**RE: Christensen Oral Surgery
9378 Valley View Dr. NW
Grading & Drainage Plan
Engineer's Stamp Date: 11/22/2024
Hydrology File: C13D025F
ABQ-PLAN File: HYDR-2025-00034**

Based upon the information provided in your submittal received 02/13/2025, the Grading & Drainage Plan **is not** approved for Grading Permit or Building Permit. The following comments need to be addressed in a resubmittal prior to approval of the above-mentioned project:

GRADING & DRAINAGE PLAN

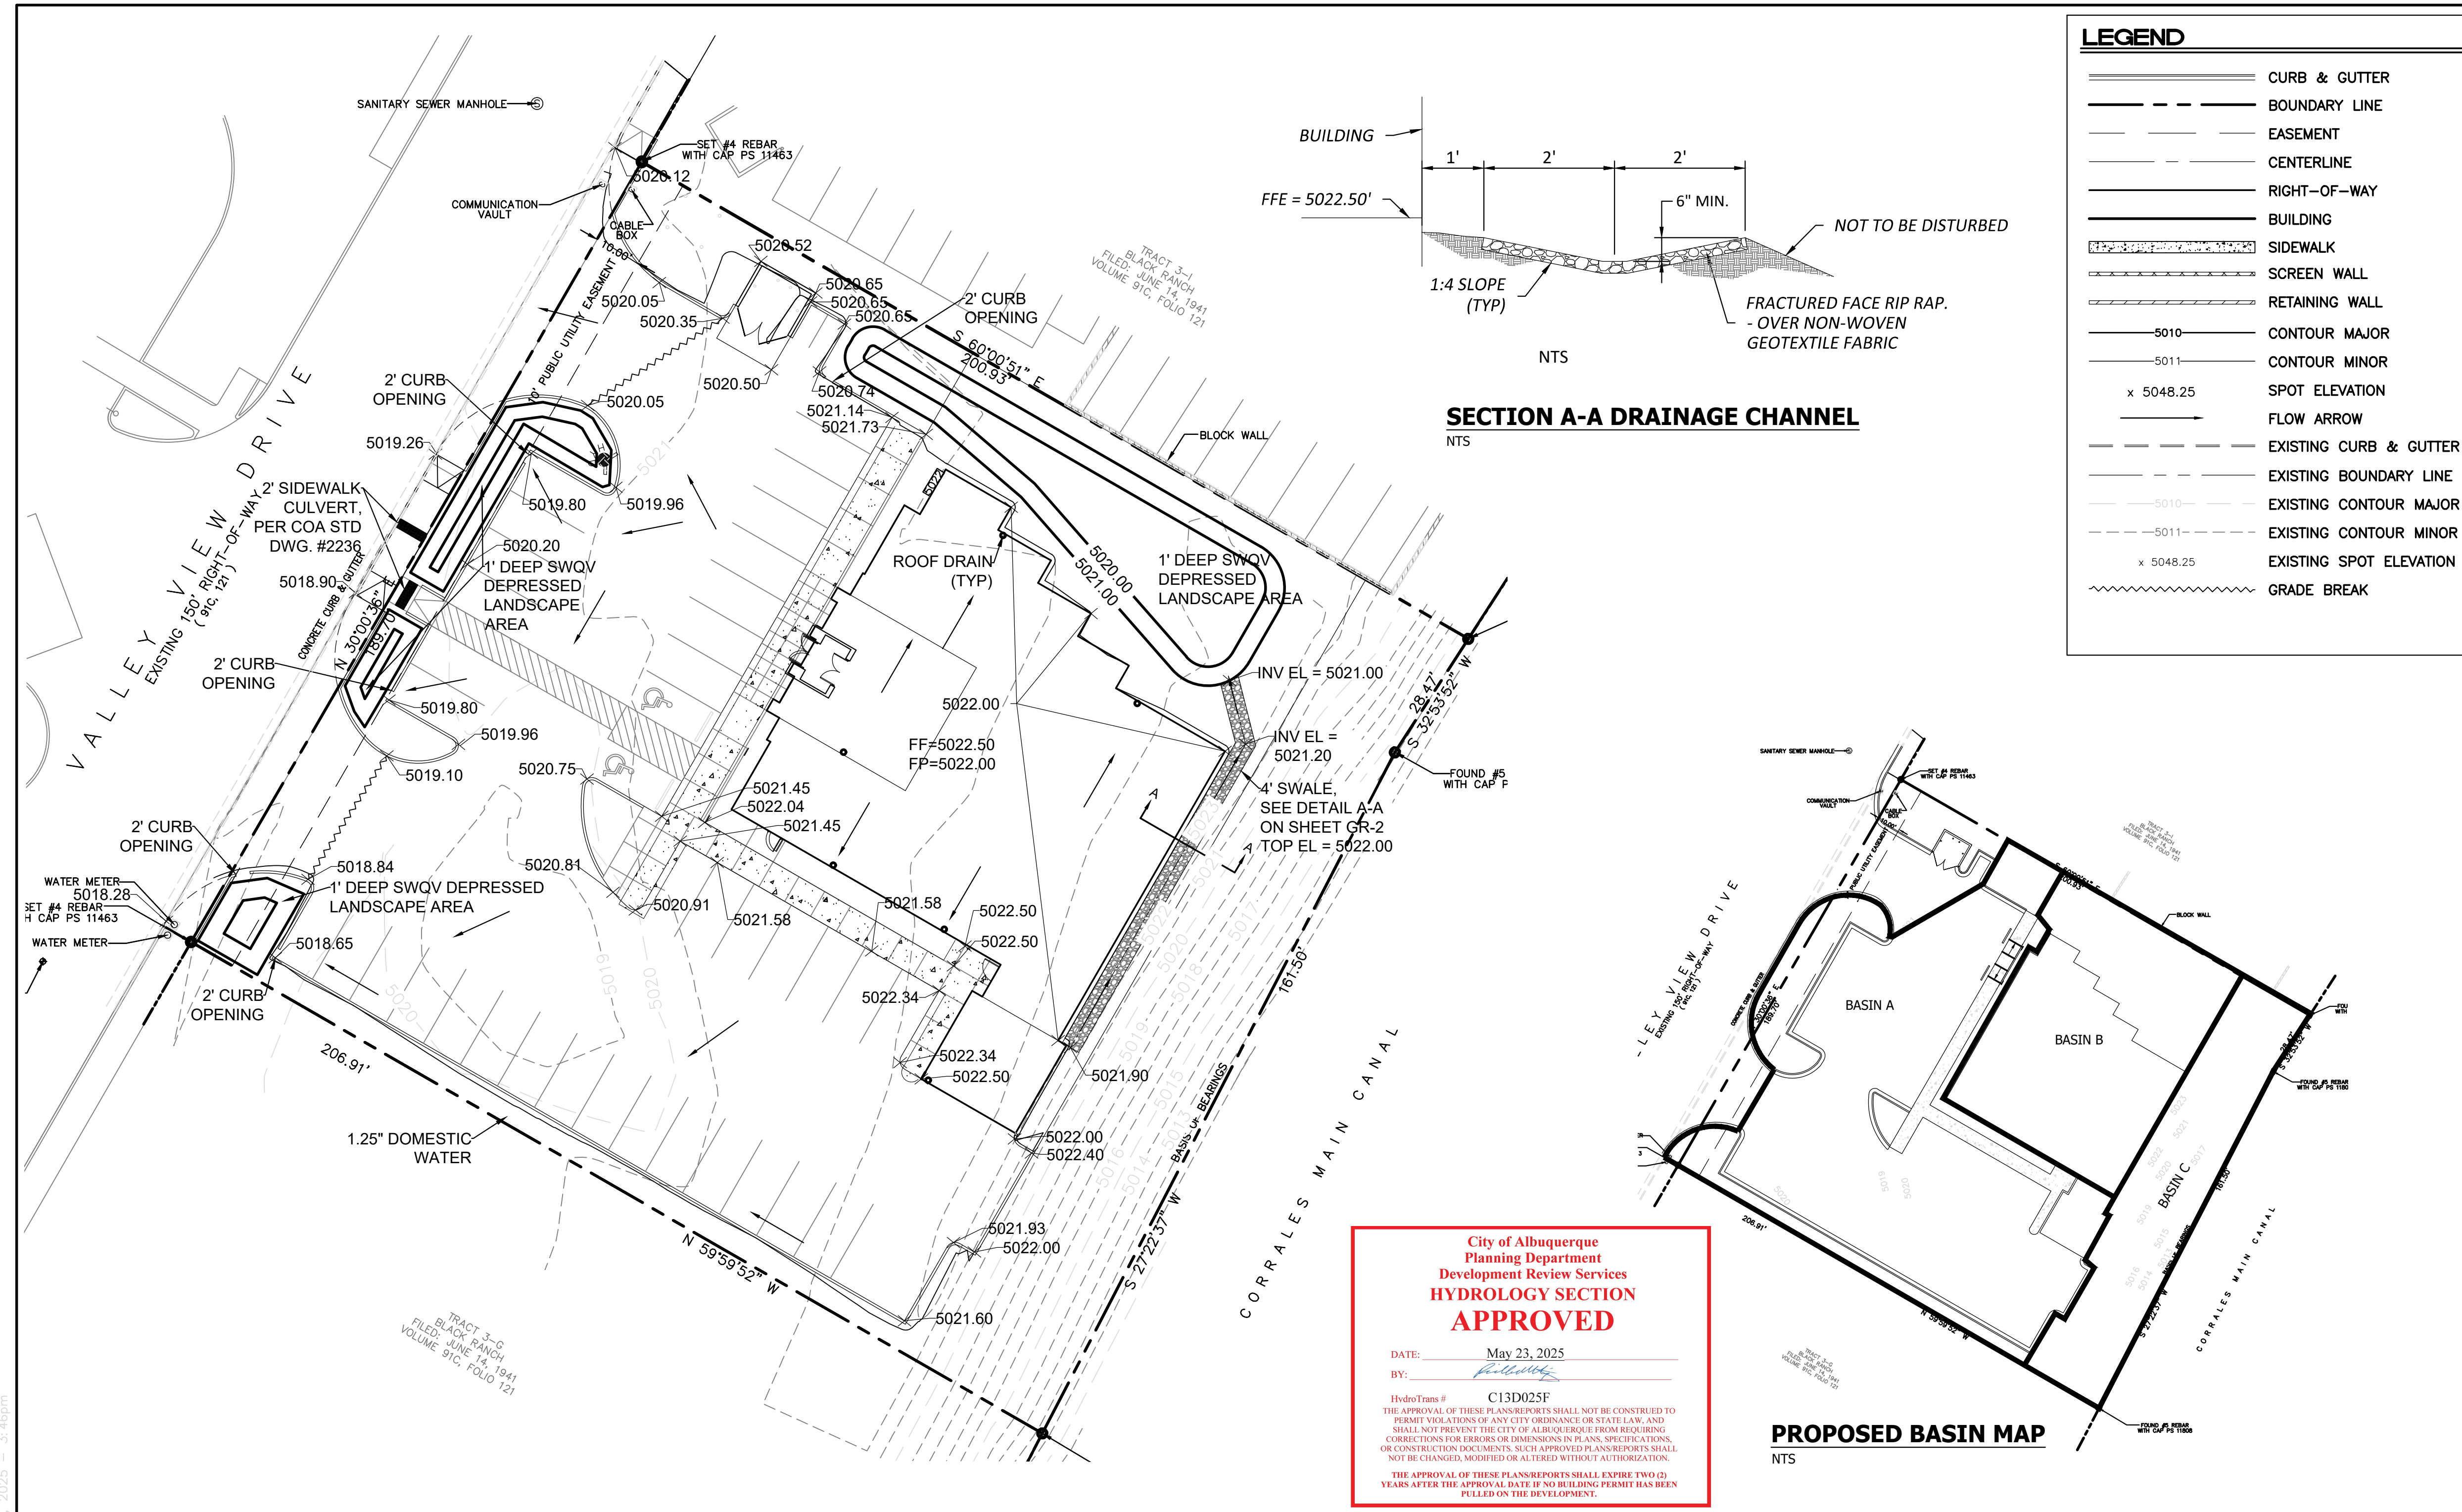
1. Sheet 1.0: Review the proposed finish grading along the easterly portion of the building and revise to show a drainage swale which would provide for storm water runoff to be directed northerly or southerly, but not against the outside wall of the proposed building structure.

2. Sheet 1.0: Review and revise to show SWQV ponds together with sidewalk culverts for each as intended to discharge through curb openings along the proposed curb alignment onto Valley View Dr. directly, and not at back of the proposed sidewalk / pedestrian refuge area.

3. Sheet 1.0: Show roof drains where appropriate and direction of storm water runoff into detention basins, SWQ ponds, or parking areas.
4. Prepare and provide Drainage Covenants for the detention ponds and private storm drains per Chapter 17 of the DPM prior to Permanent Release of Occupancy. Please submit on the 4th floor of Plaza de Sol. A \$25 fee will be required.
